**RE: MP09_0187 MOD 2 - RESPONSE TO THE DEPARTMENT'S REQUEST FOR
ADDITIONAL INFORMATION**
PROPERTY: NOS. 6-16 ATCHISON STREET, ST LEONARDS

I am writing with regard to the above Section 75W Application and the Department's email correspondence dated 29 July 2013 which included a letter from North Sydney Council dated 16 July 2013. Each of the items raised in this correspondence are addressed below and are supported by amended plans which are attached with this submission.

NORTH ELEVATION

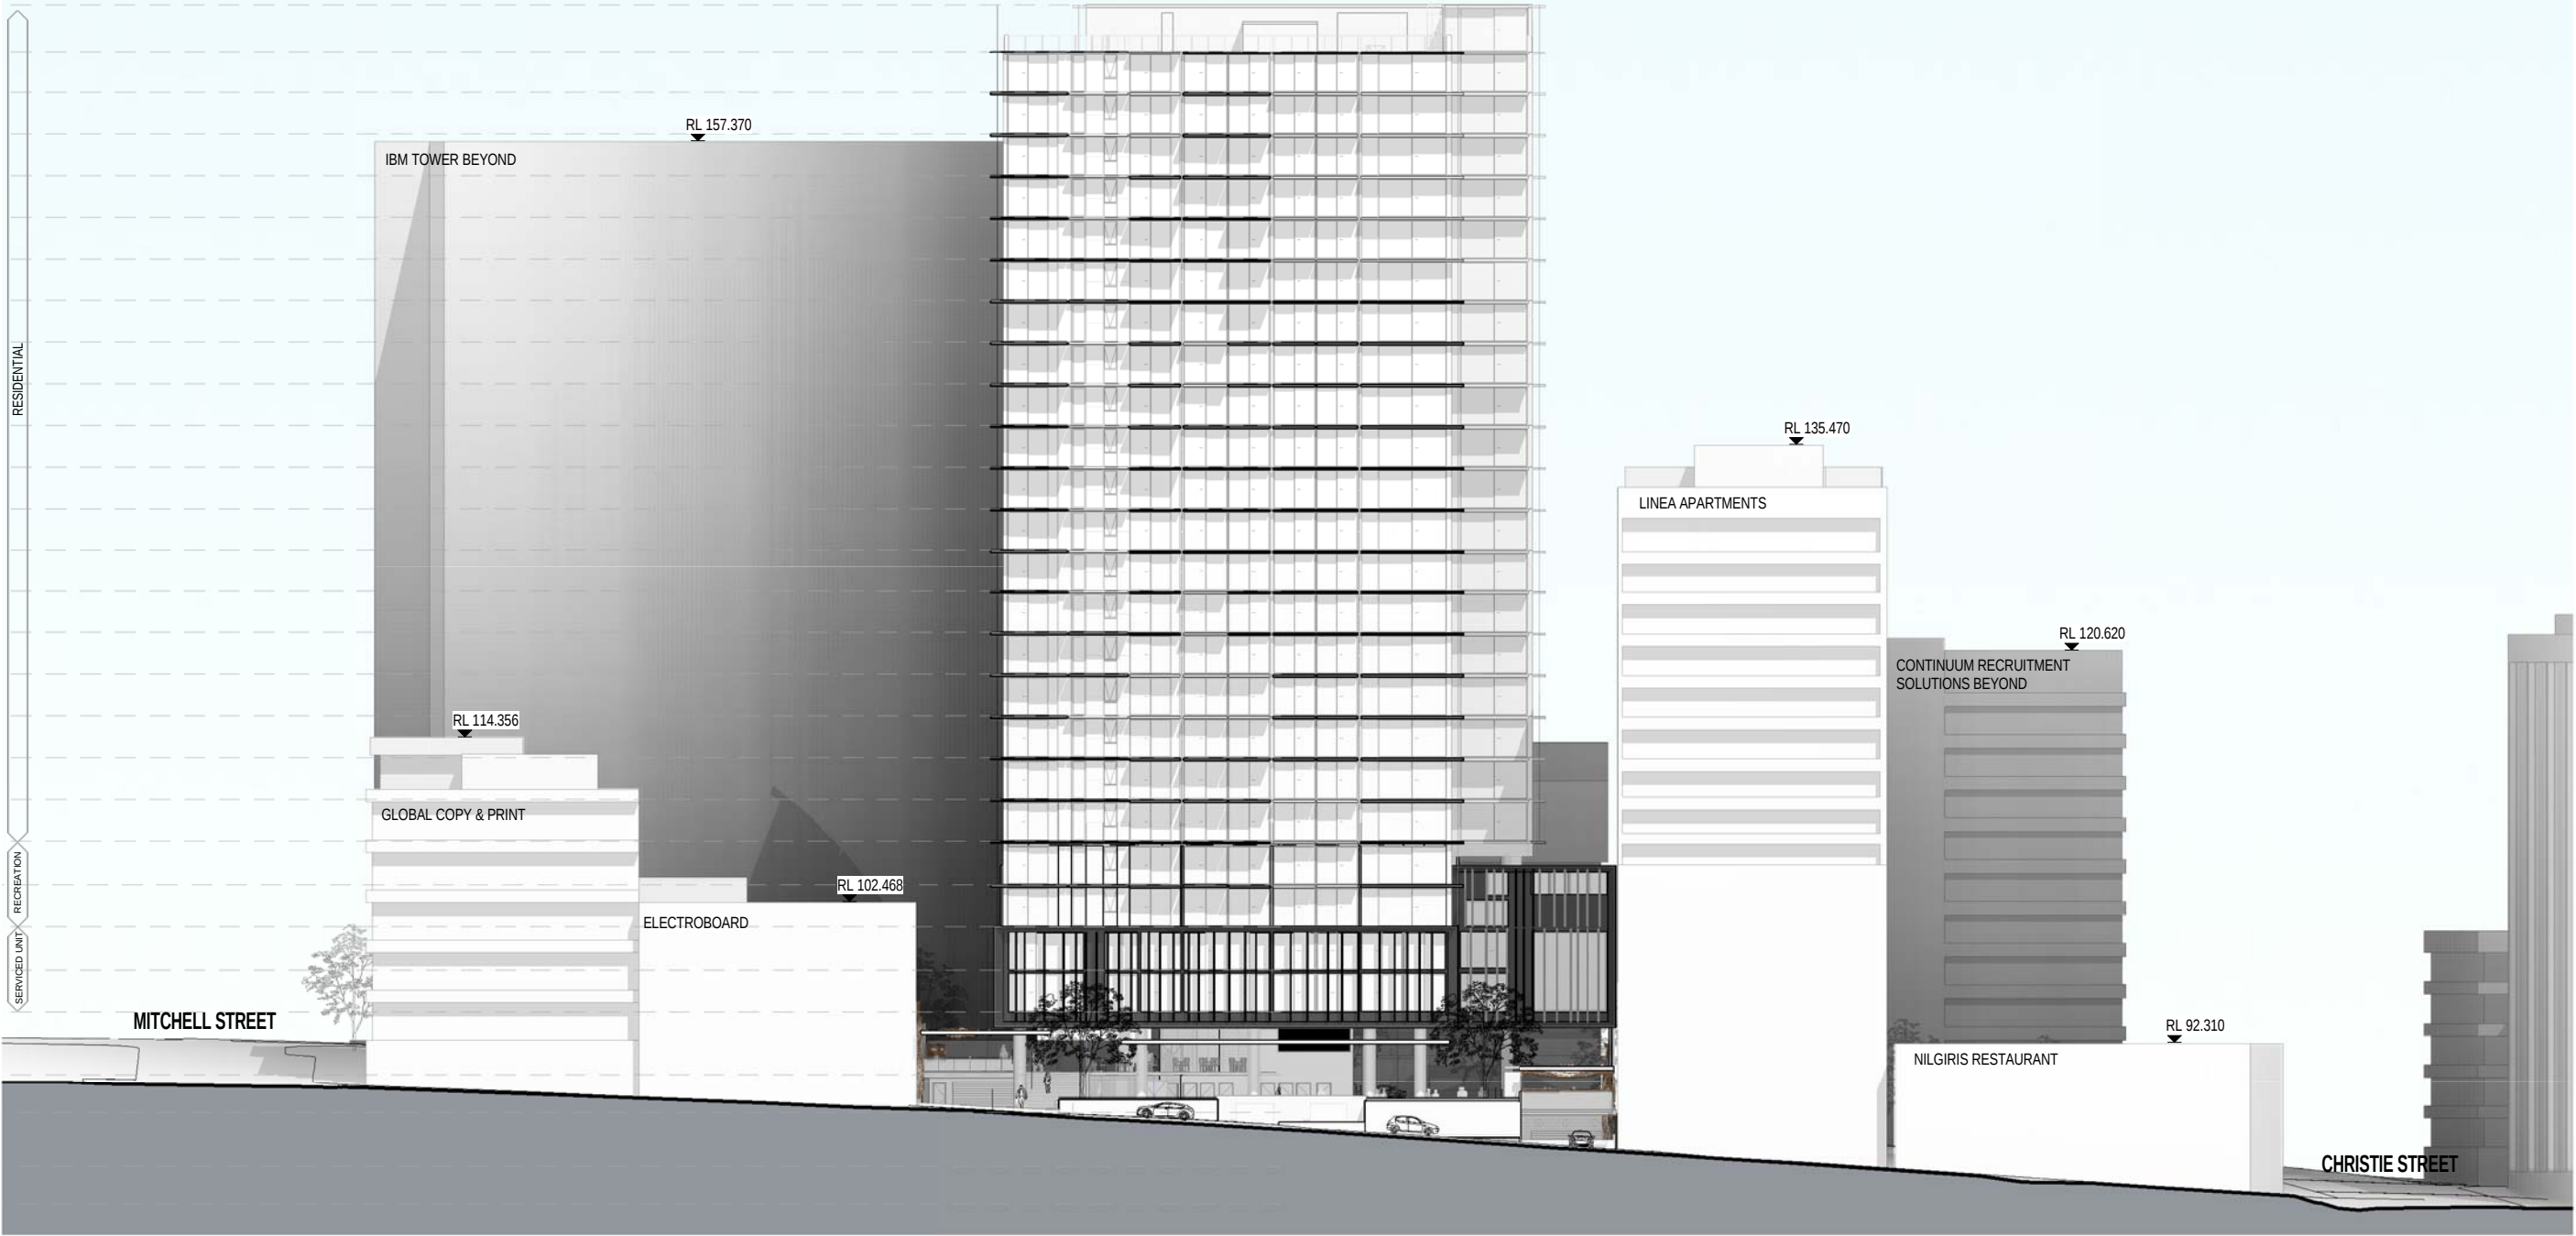
- ii) The DoPI requests further information regarding the articulation of the southern façade and recommends an appropriate outcome which considers the limited solar access to the southern facade, and articulation such as introducing solid elements to provide some variation to the façade and a distinction between the northern and southern elevations.

From a functional standpoint the projections serve both as sun and rain control on the northern facade and to reduce rain ingress through open windows on the southern facade. Therefore, these elements serve an important function on the south façade. The dual treatments and juxtaposition of the east / west and north / south facades provide an appropriate contrast. The introduction of a third façade treatment is neither warranted nor desirable, therefore the proposal seeks to retain these elements.

LEVEL4

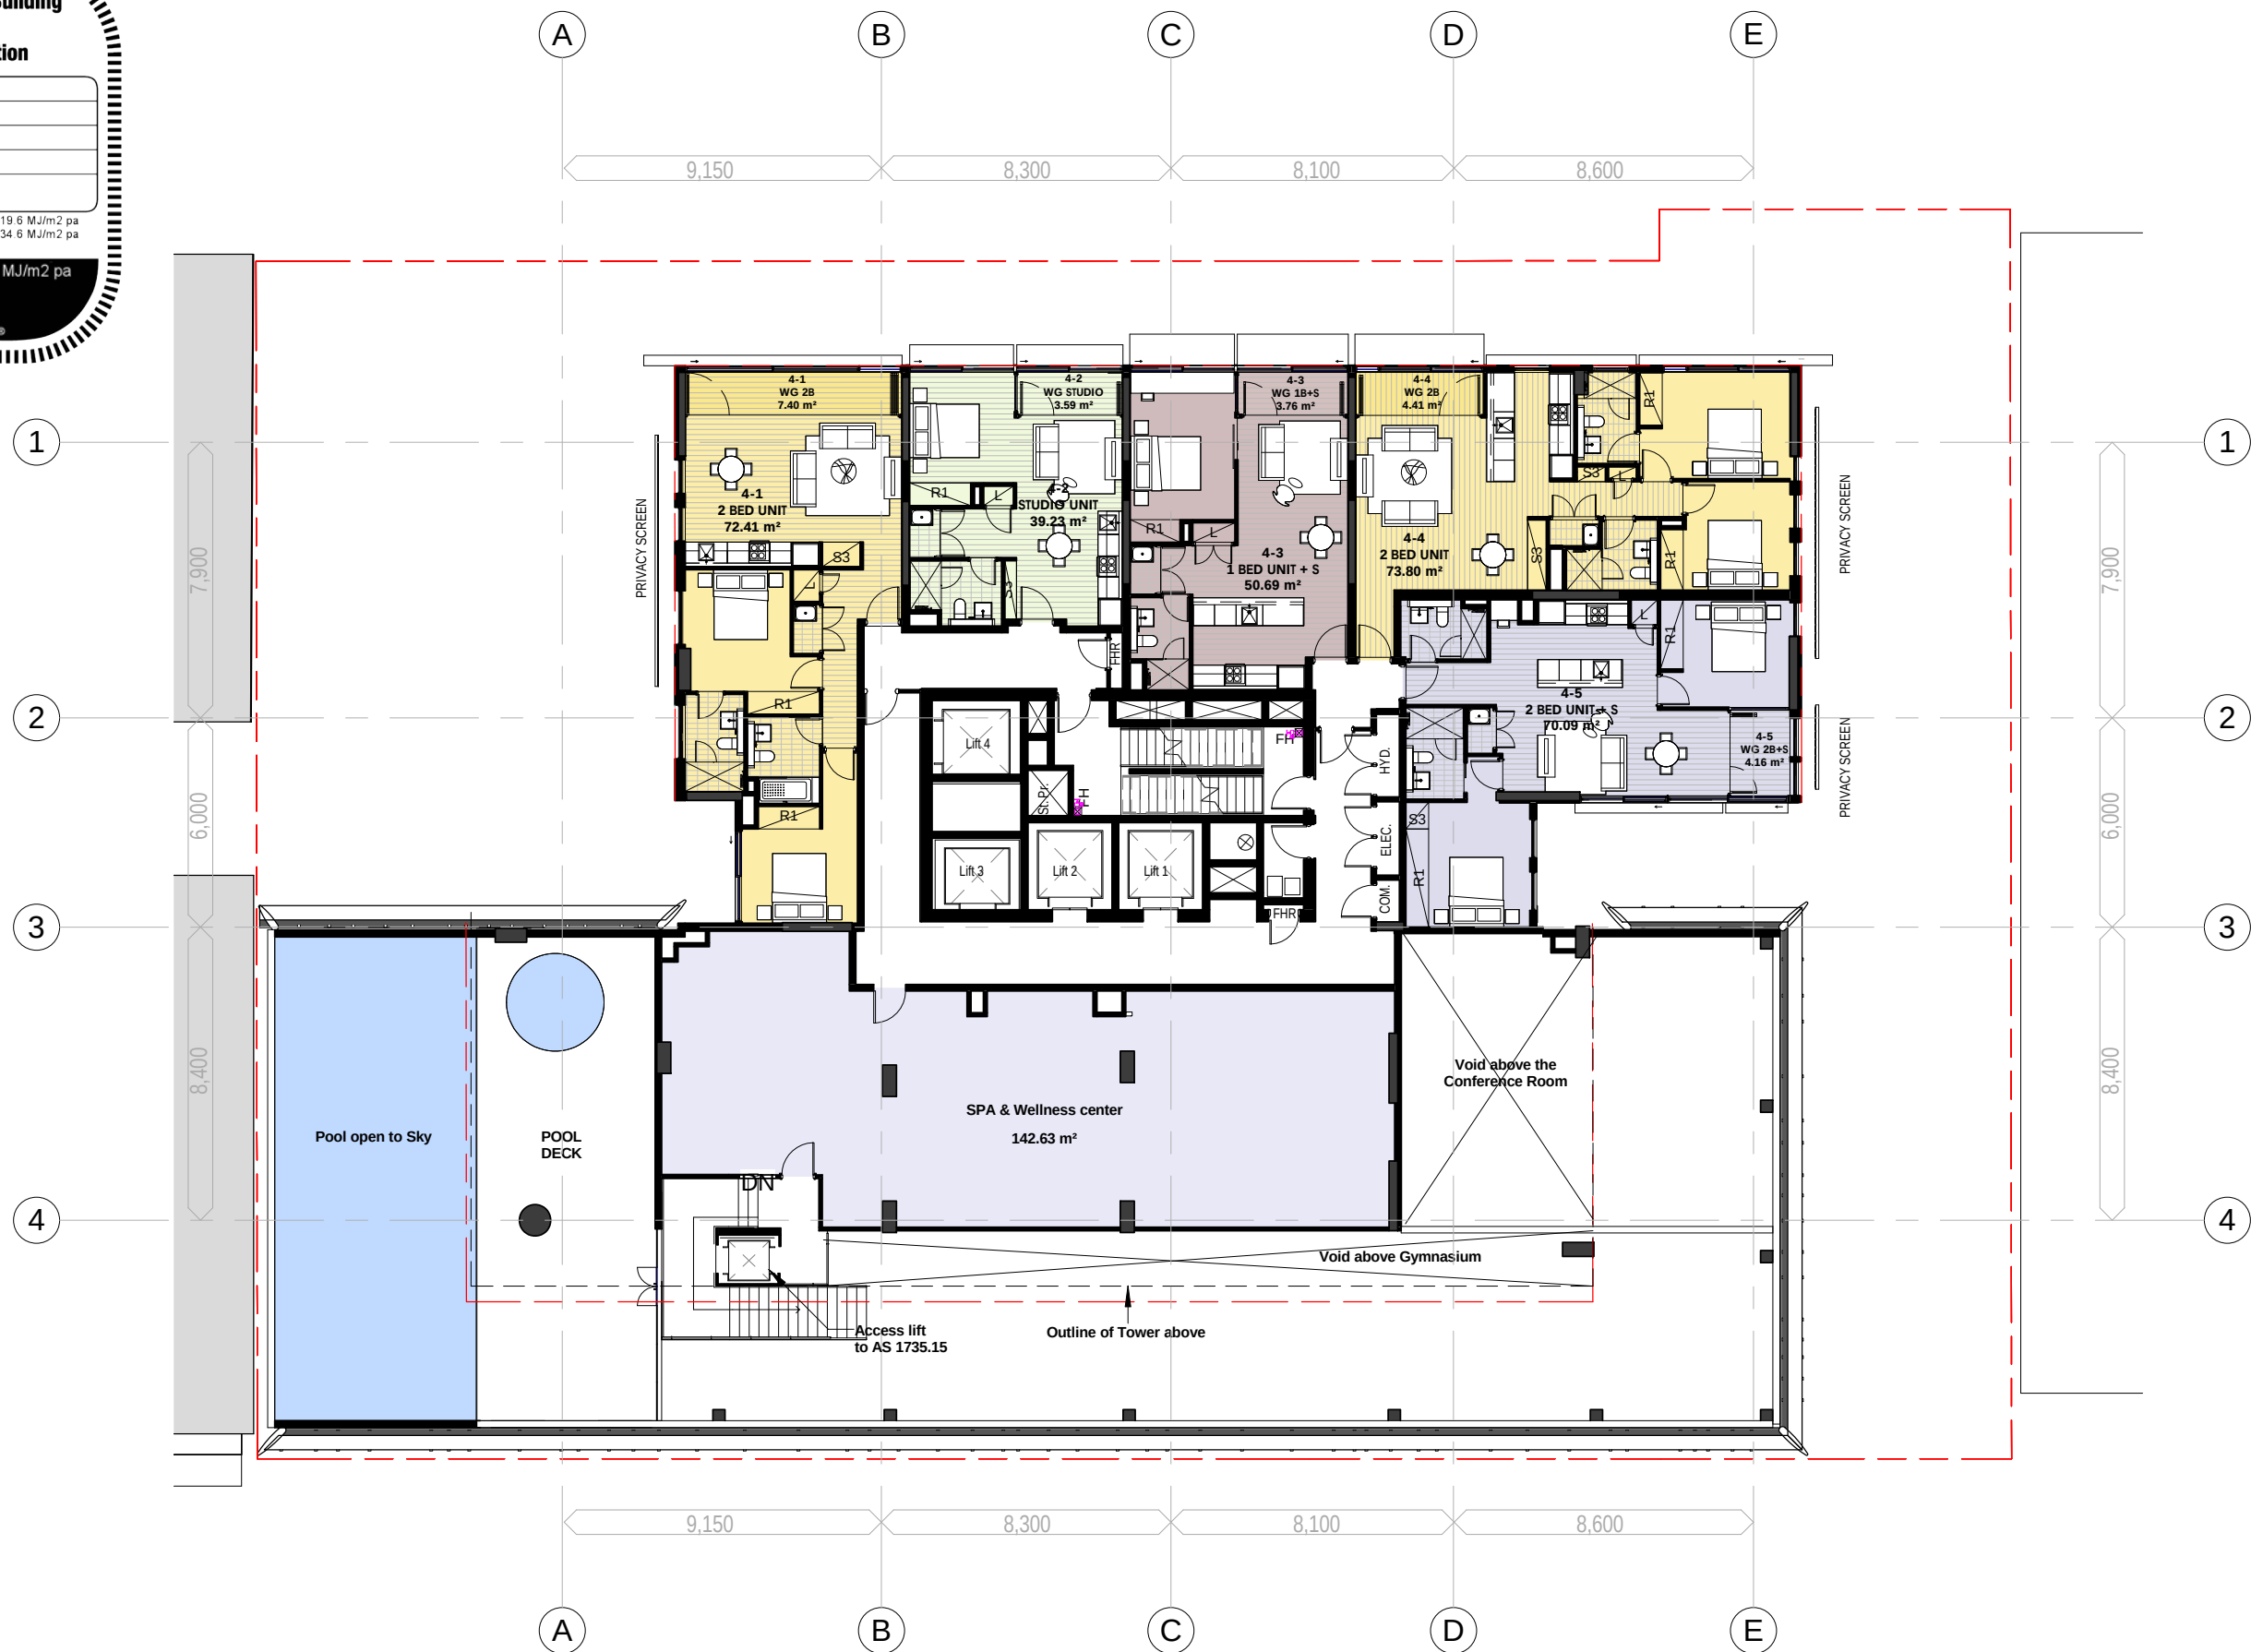
- c) Council raises concern with regard to the lack of separate lifts and corridor access for residential apartments and non-residential wellness centre on Level 4.

The Wellness Centre is to be accessed via Level 3. The corridors on Level 4 are dedicated for the use of residents, except in the case of an emergency when alternative egress from the gymnasium / pool / wellness centre is provided via Level 4.
